From: [REDACTED]
Sent: 17 December 2019 14:30
To: A38 Derby Junctions <A38DerbyJunctions@planninginspectorate.gov.uk>
Subject: RE: TR010022 - A38 Derby Junctions highway improvement scheme

QUESTIONS TO HIGHWAYS AGENCY ABOUT THEIR A38TRUNK PROPOSALS

Designed	Drawn	Checked	Approved	Date
LB	TWS	GS	GS	04/03/19
Internal Project No.	Suitability			
60533462	S3			
Scale @ A1	Zone			
1:2500	A38/A5111 Kingsway

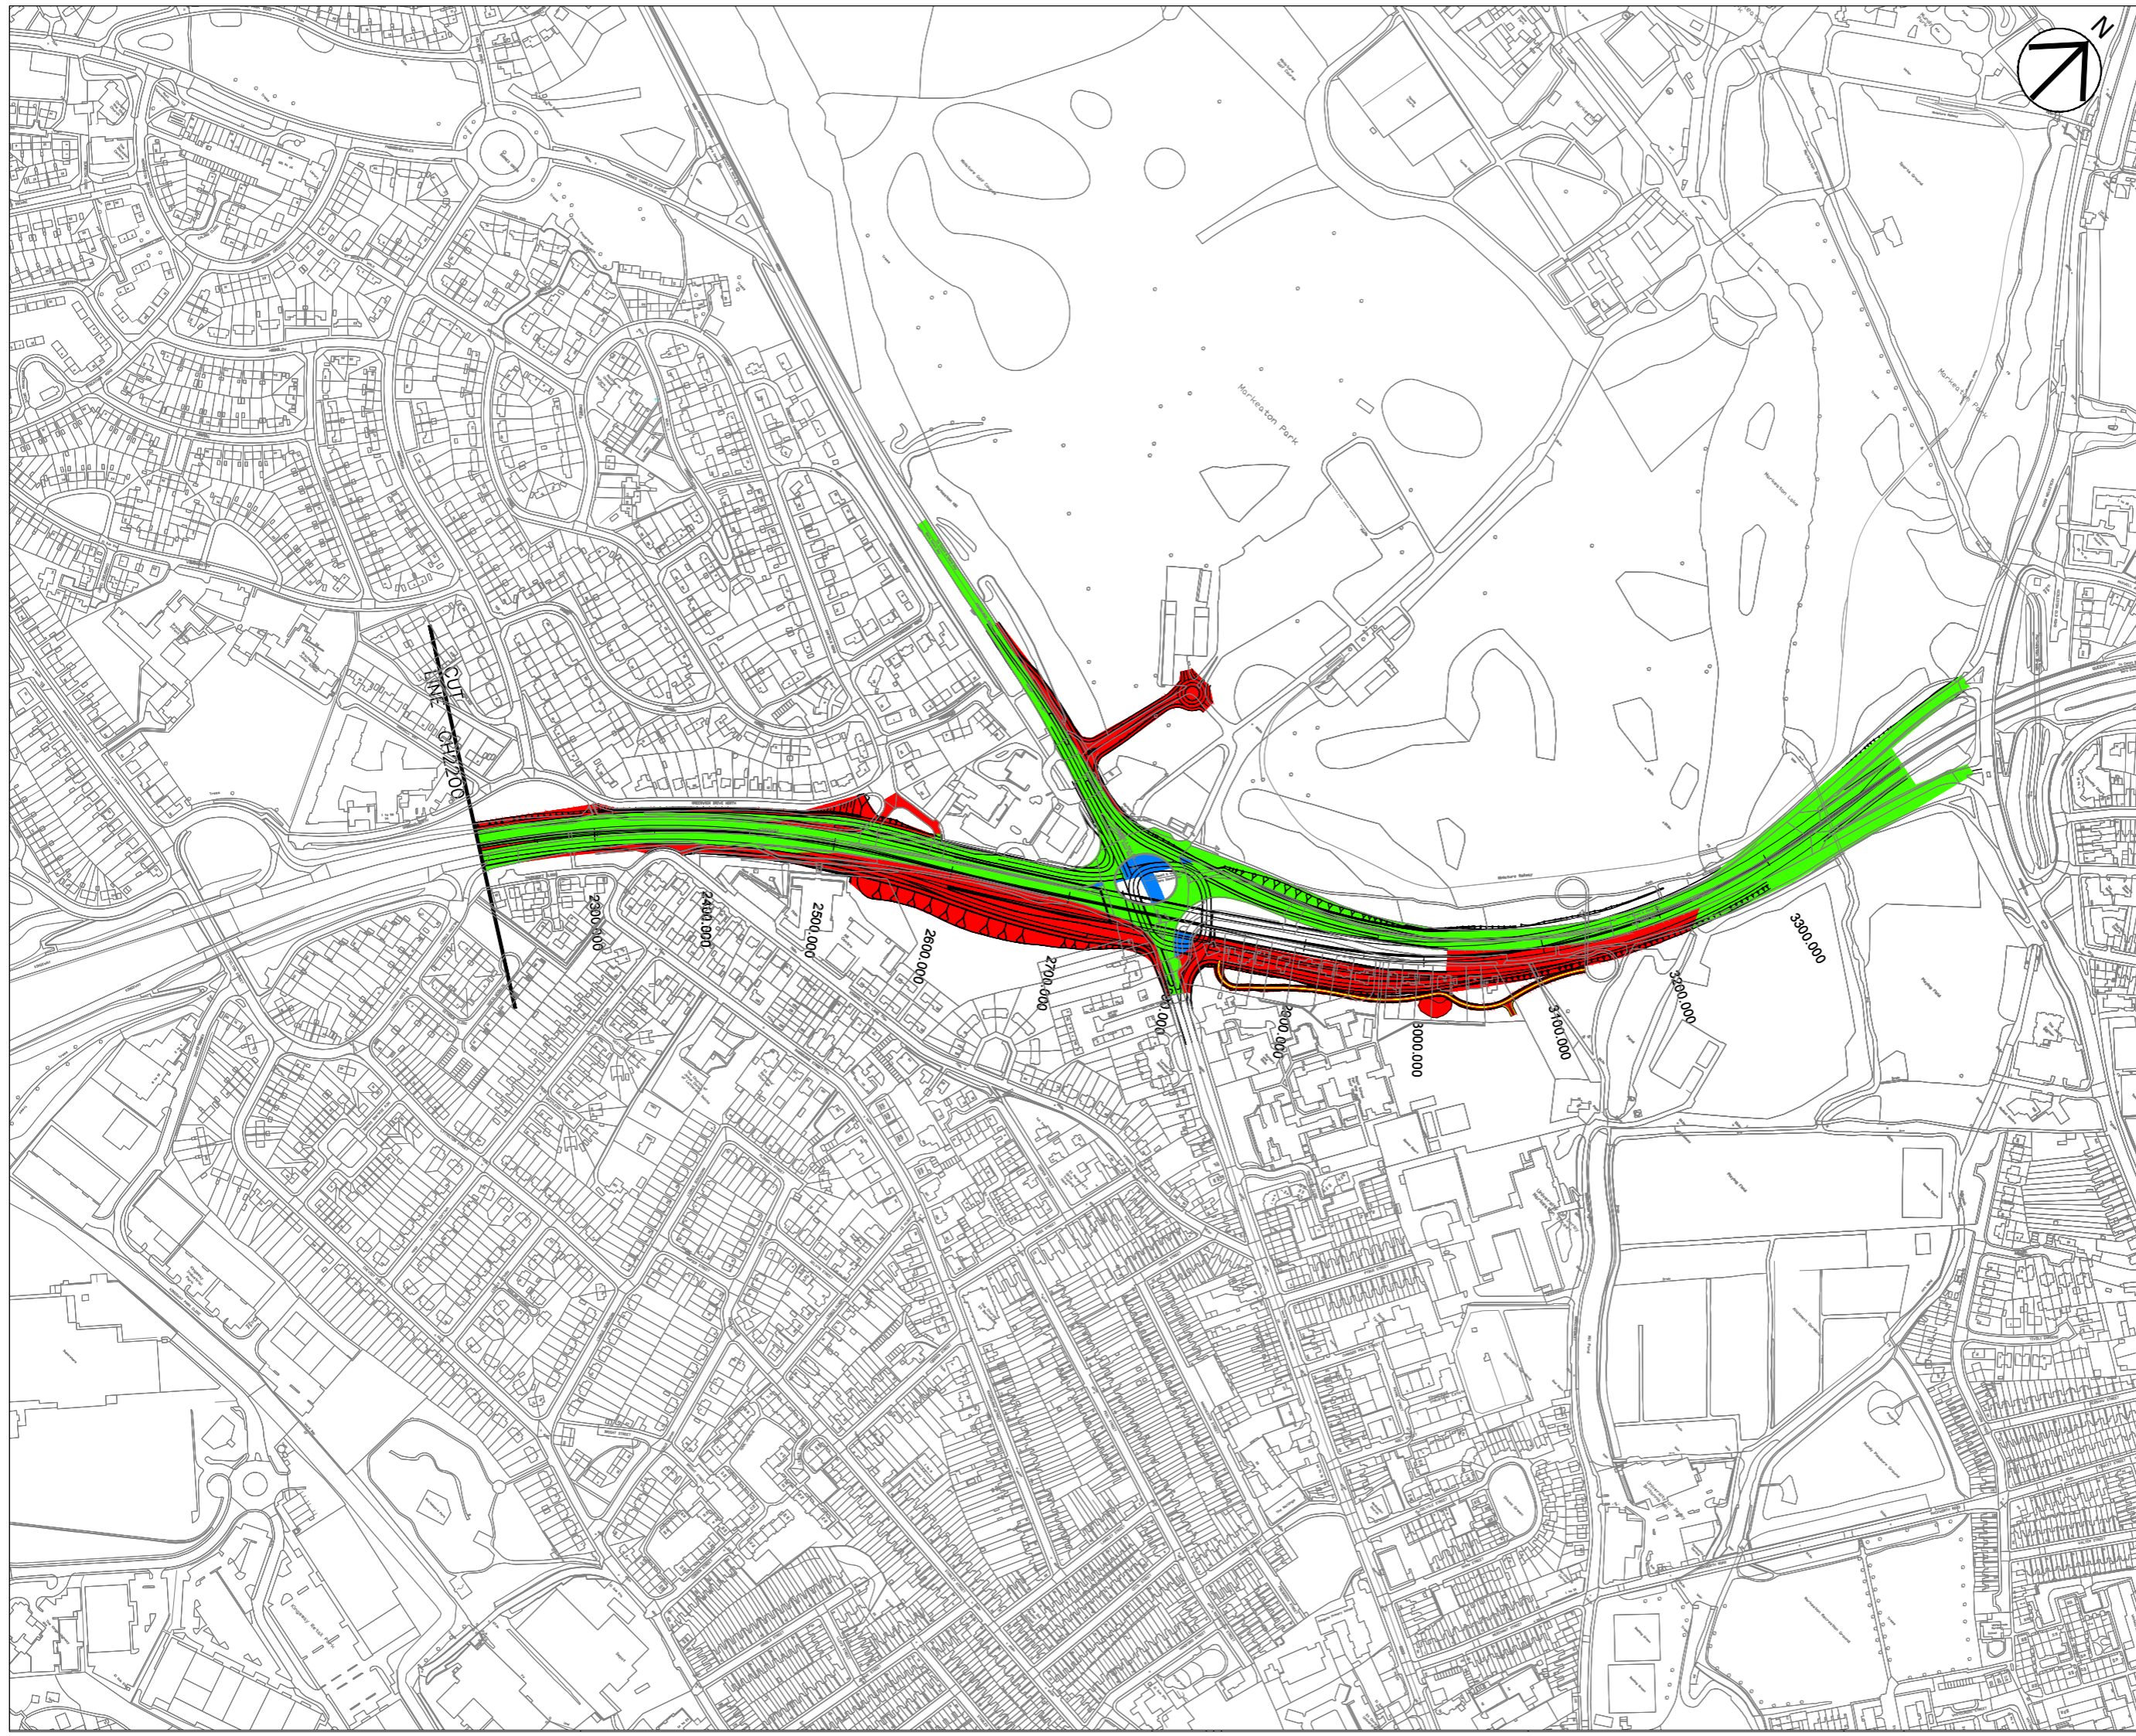
2 How will the HA construct 8 new bridges, new carriageways and new roundabouts ON THE LINE OF THE EXISTING ROAD without leading to massive delays for the 10,000+ vehicles a day on the A38T and for Derby urban traffic for 3 years ? The last attempt by HA in 2015 of “Interim Improvements” at Markeaton and Little Eaton, involving only fitting traffic lights and an extra carriageway at these roundabouts, led to enormous chaos and delays DAILY for 6 months. How will HA keep the traffic moving ? Will it be diverted down A6 Duffield Road and Broadway, where there are 3 schools ?

3 Why are there 7 Junctions of the A38T with Derby? All are not needed, especially Kingsway junction and Kedleston Road Junction, especially if the proposal in 2) above is implemented. Kingsway junction can be eliminated if the Uttoxeter Road Junction is made bi-directional with a new bridge, making this the major south-Derby junction leading along this dual carriageway into town . This work can be carried out OFF-ROAD..

**LITTLE EATON JUNCTION  
 PROPOSED CONSTRUCTION  
 SEQUENCE  
 PHASE 4**

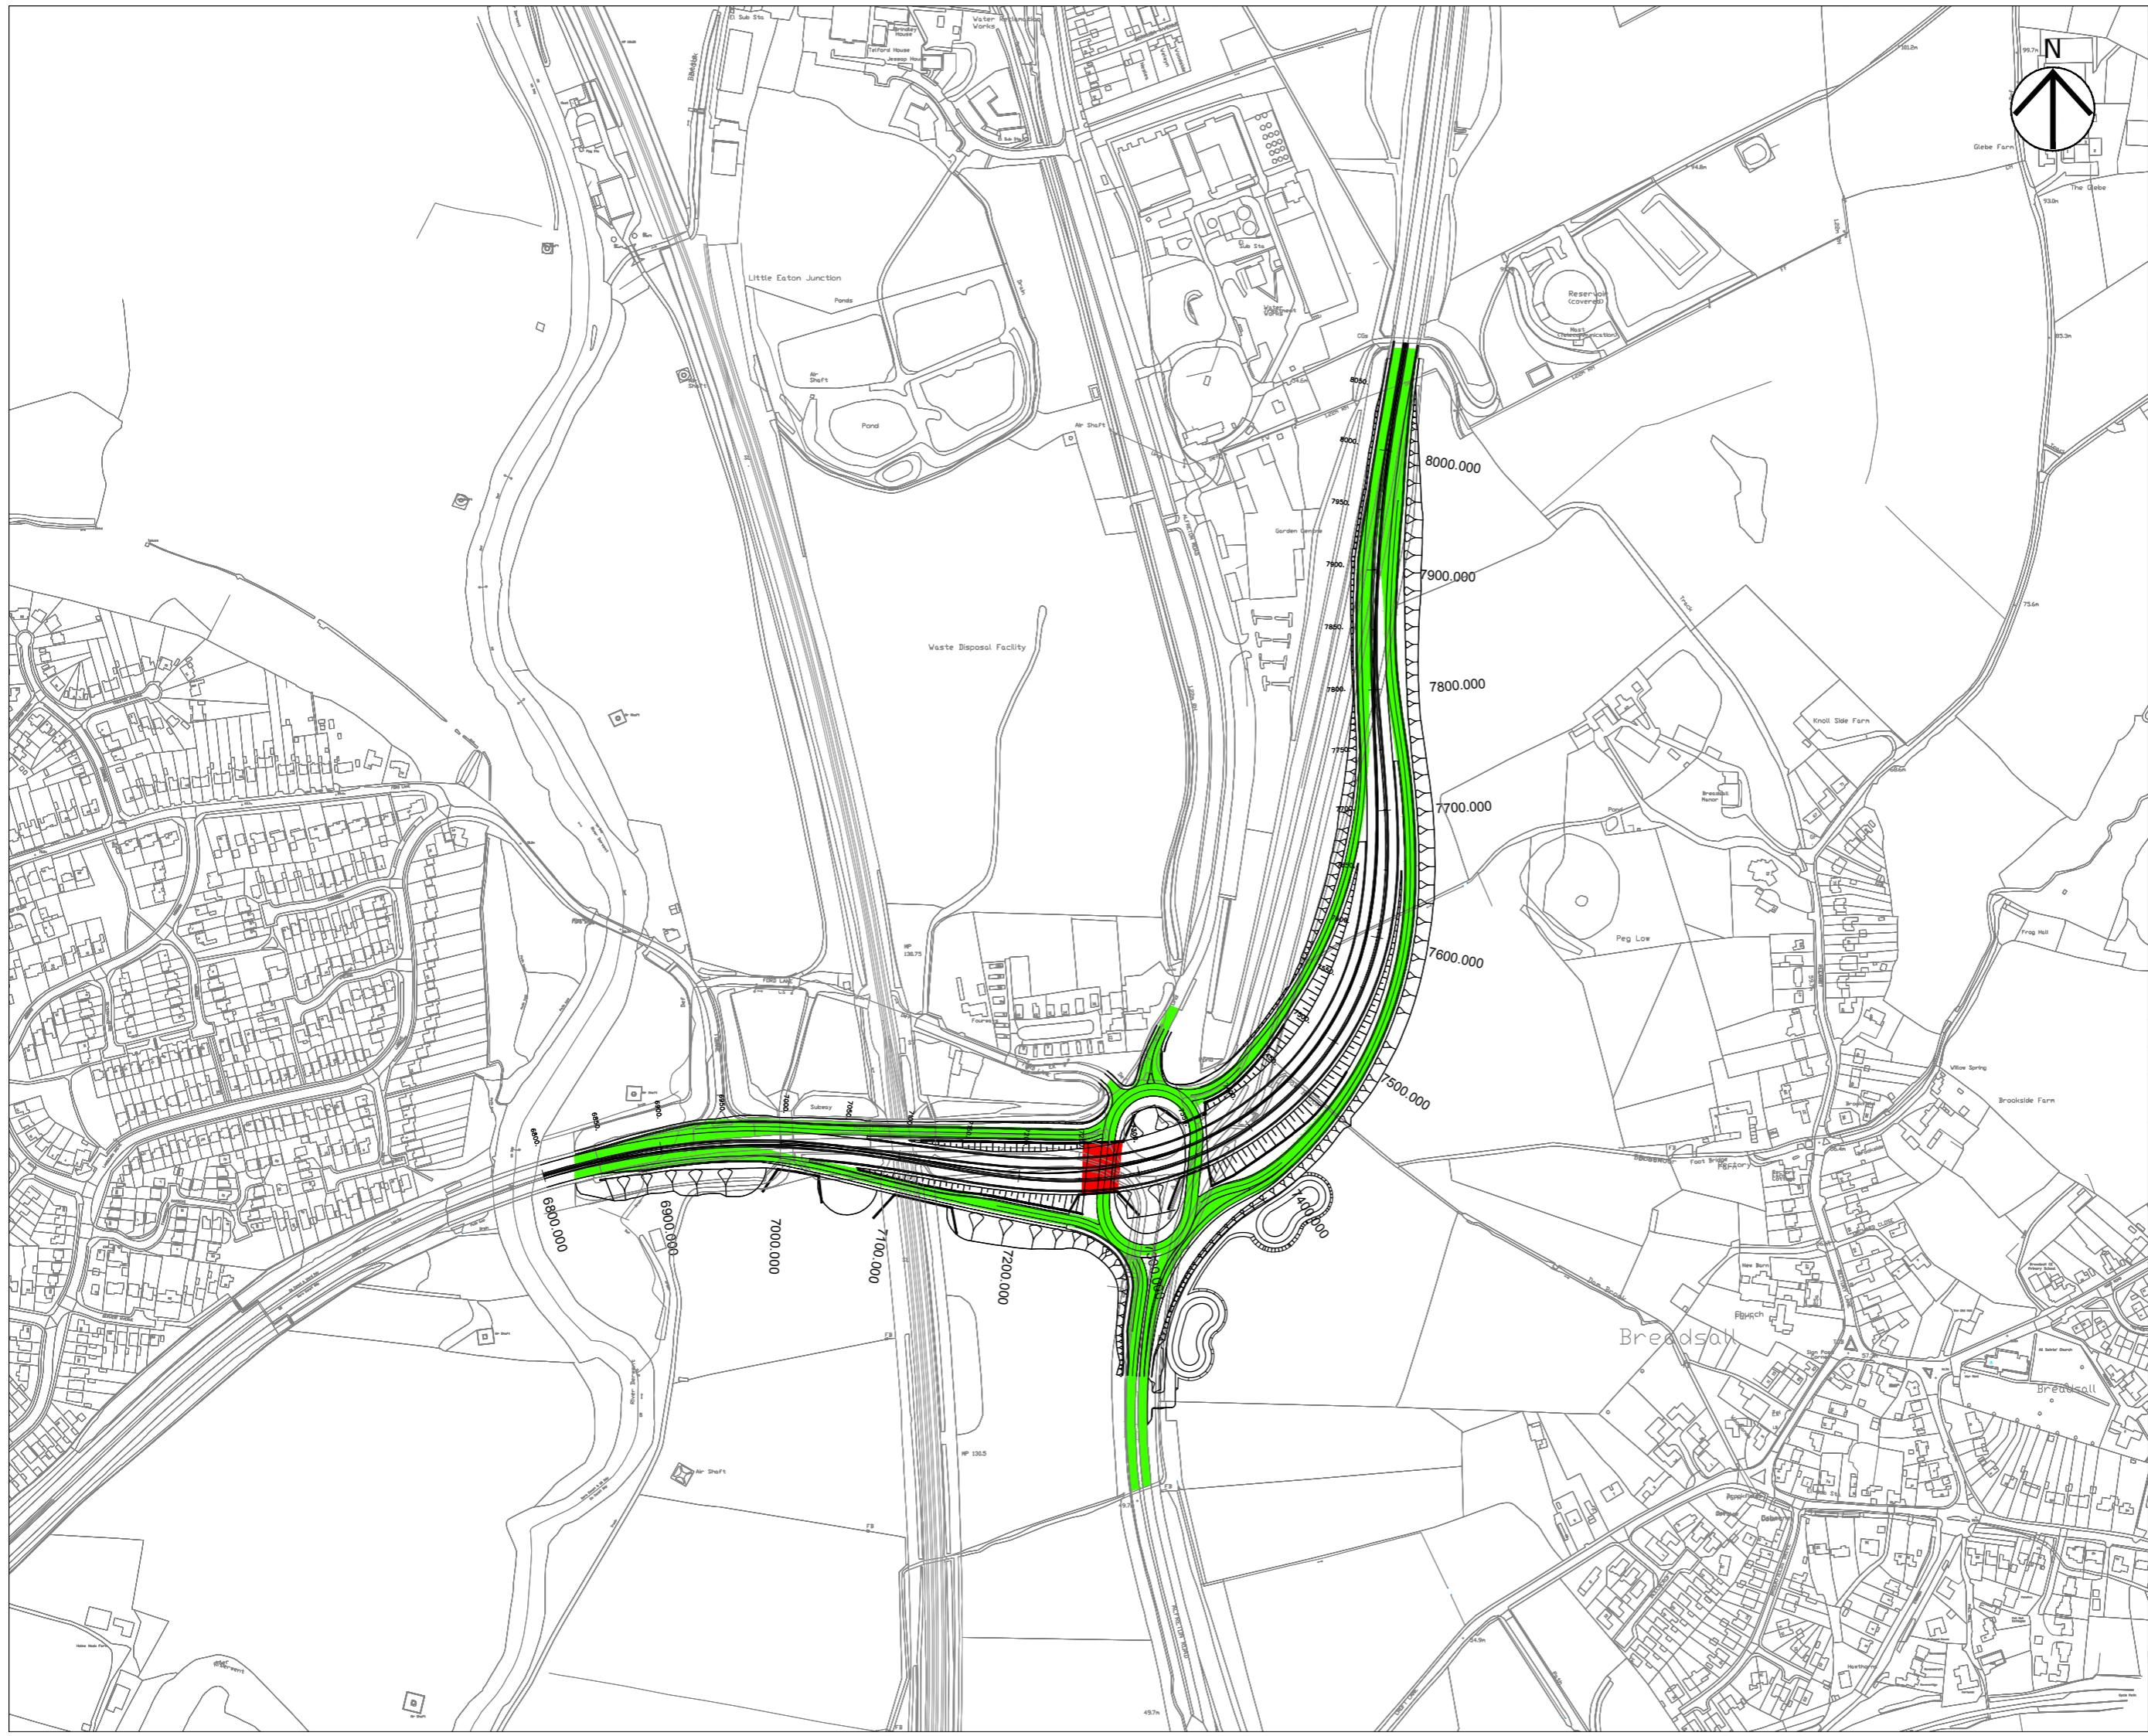
4 Why are two bridges being built at Little Eaton over the roundabout and two new carriageways and 2 bridges being built over the railway line, all ON THE ROAD LINE, when a single bridge could take the A61 over the ground-level A38T. The HA plan is overkill. The A38T can be swerved north through the Garden Centre to soften the bend, and two OFF-ROAD roundabouts can be built north & south of the junction on available land for leaving/joining traffic, copying the HA “preferred solution” for the Kingsway Junction. This would reduce the visual impact and noise levels at the junction.
